From: Neil Crowther
Sent: 15 June 2017 09:41
To: Andrew Wood; Planning.Responses
Cc: sally henderson [REDACTED]
Subject: FG/198/16/PL

From: sally henderson [REDACTED]
Sent: 14 June 2017 23:01
To: Neil Crowther
Subject: SCAN

Please find attached the scanned site plan showing the overlooking sight lines into the rear of our property and into our private hot tub.

JOB: 1 SEA DRIVE, FERRING, WORTHING BN12 5HD
DWG: PROPOSED SITE PLAN

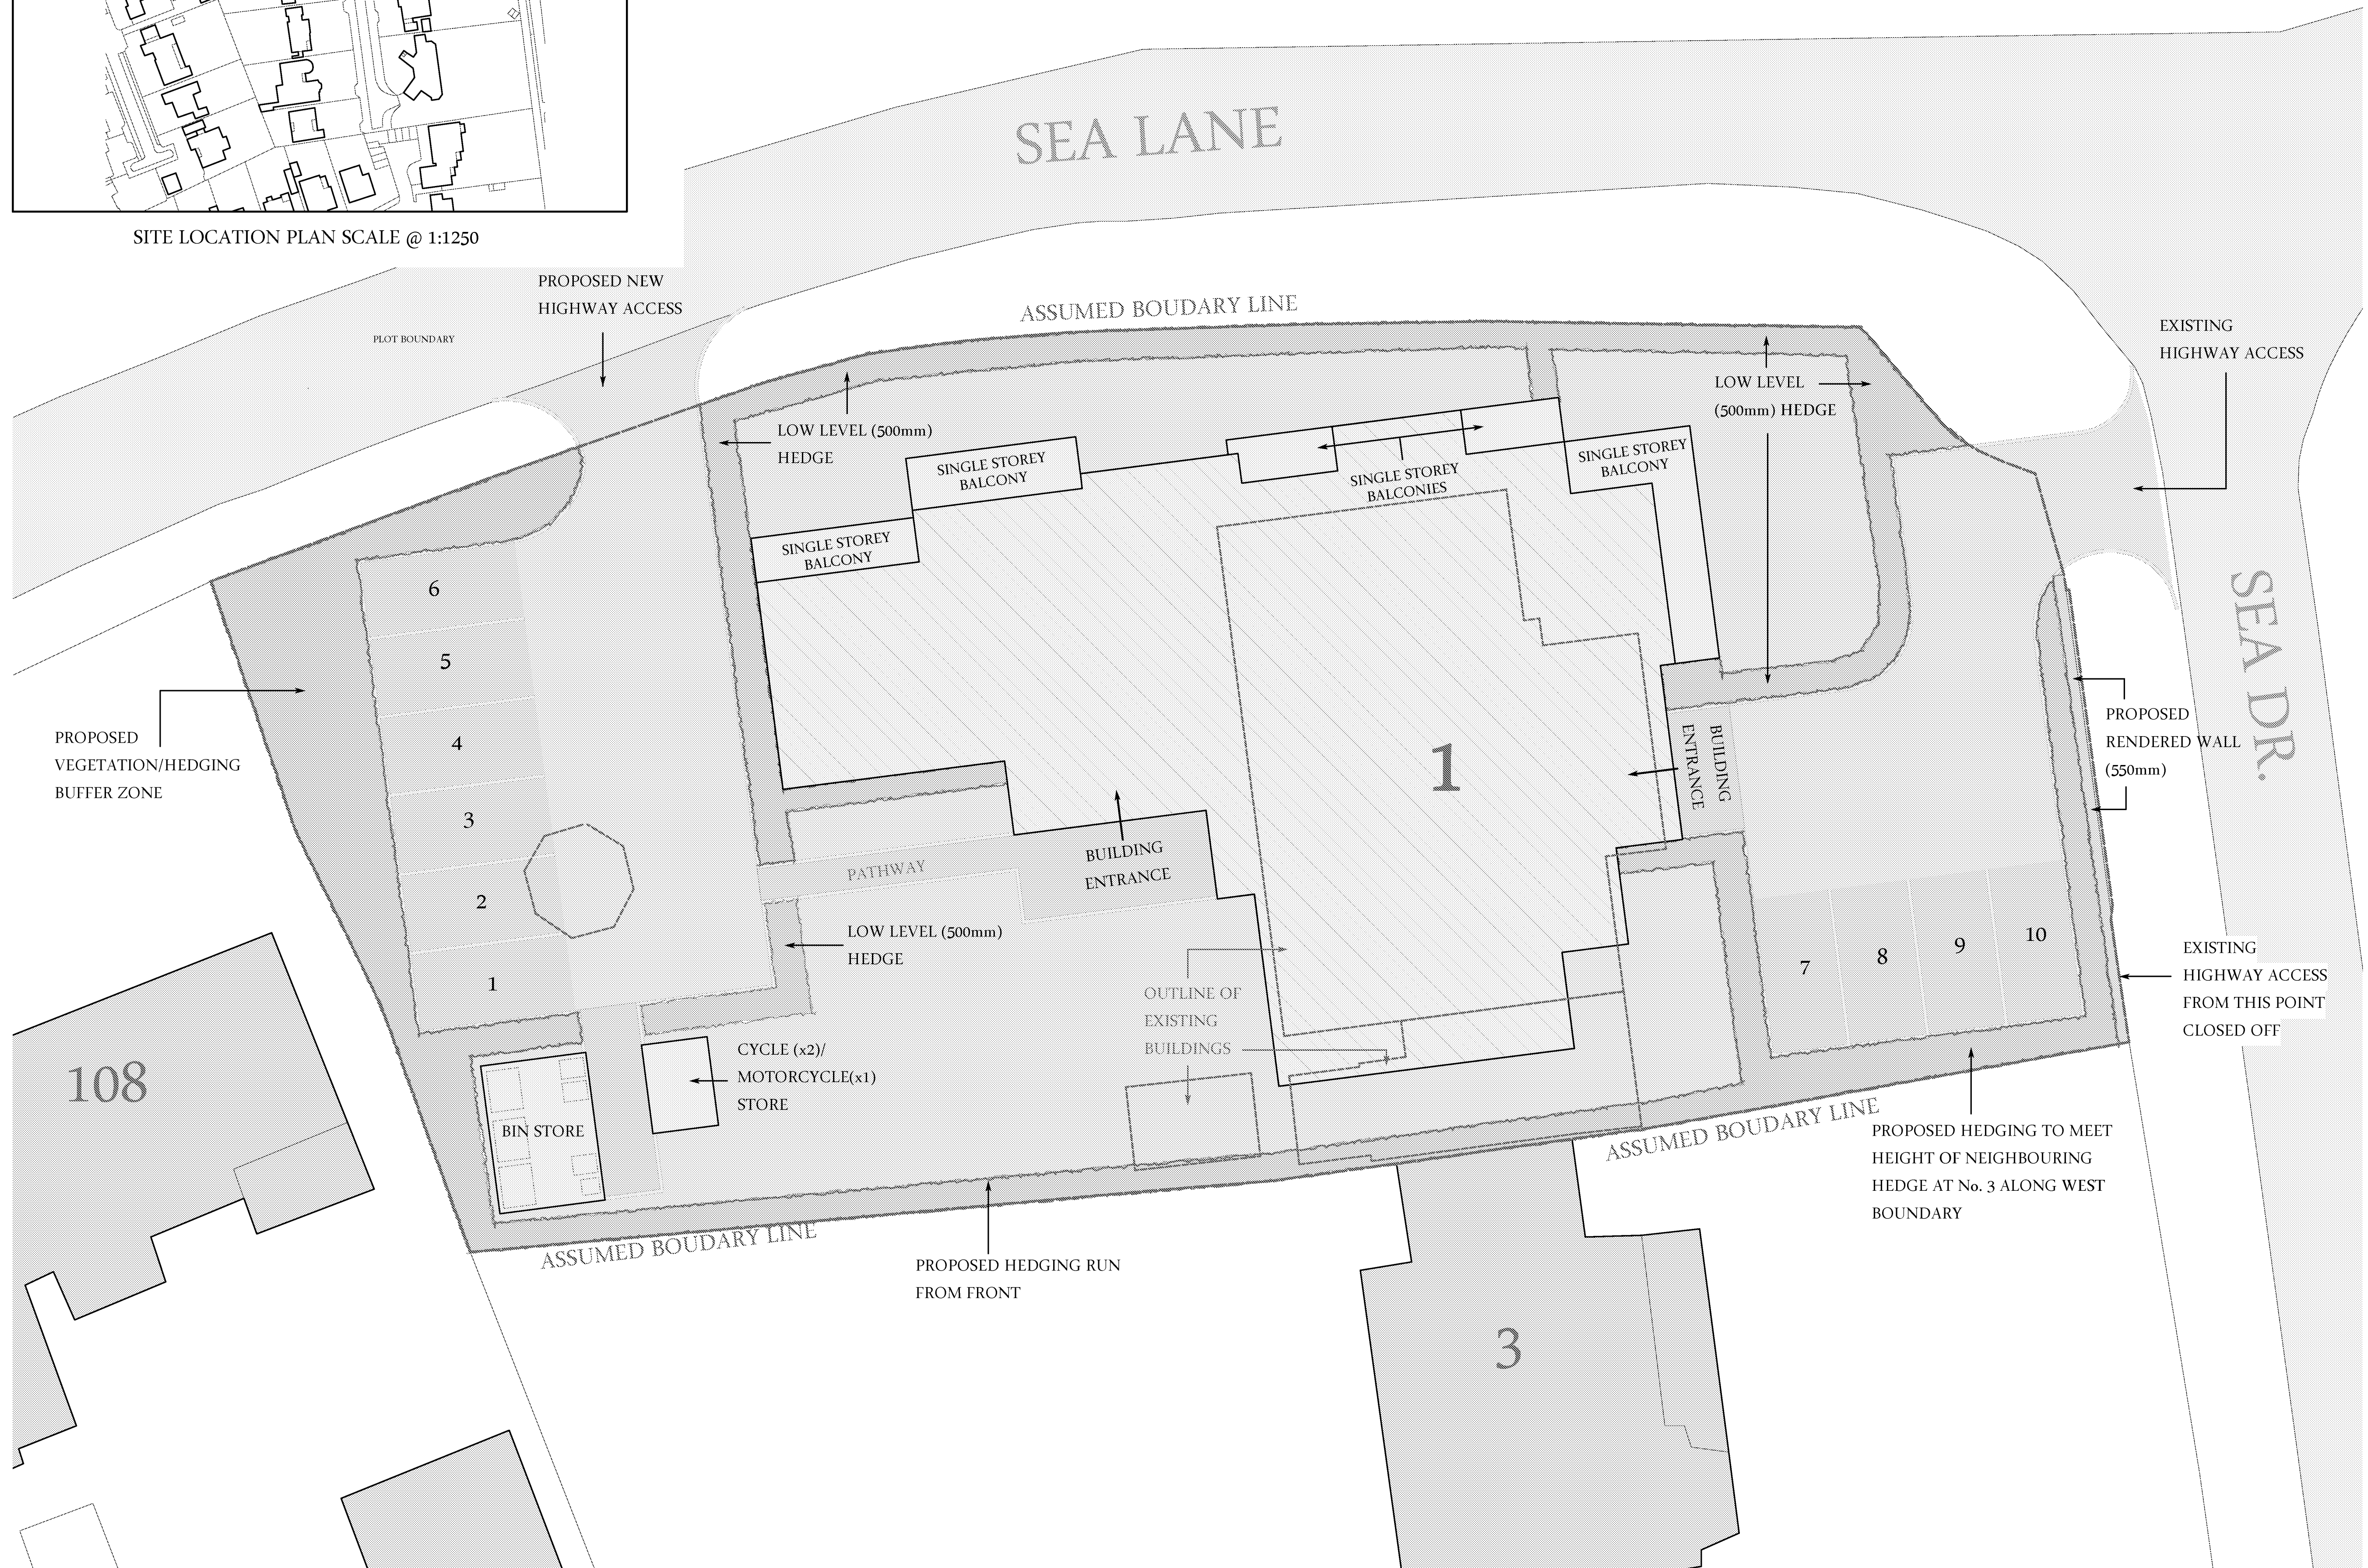
Please also note that the access splays shown by the applicant for access to the underground car park are not possible since they have shown the splays crossing our land. I have highlighted this, and this boundary can be confirmed by referring to the land registry filed plans for 3 Sea Drive or by a site visit where the different driveway finishes highlight the boundary.
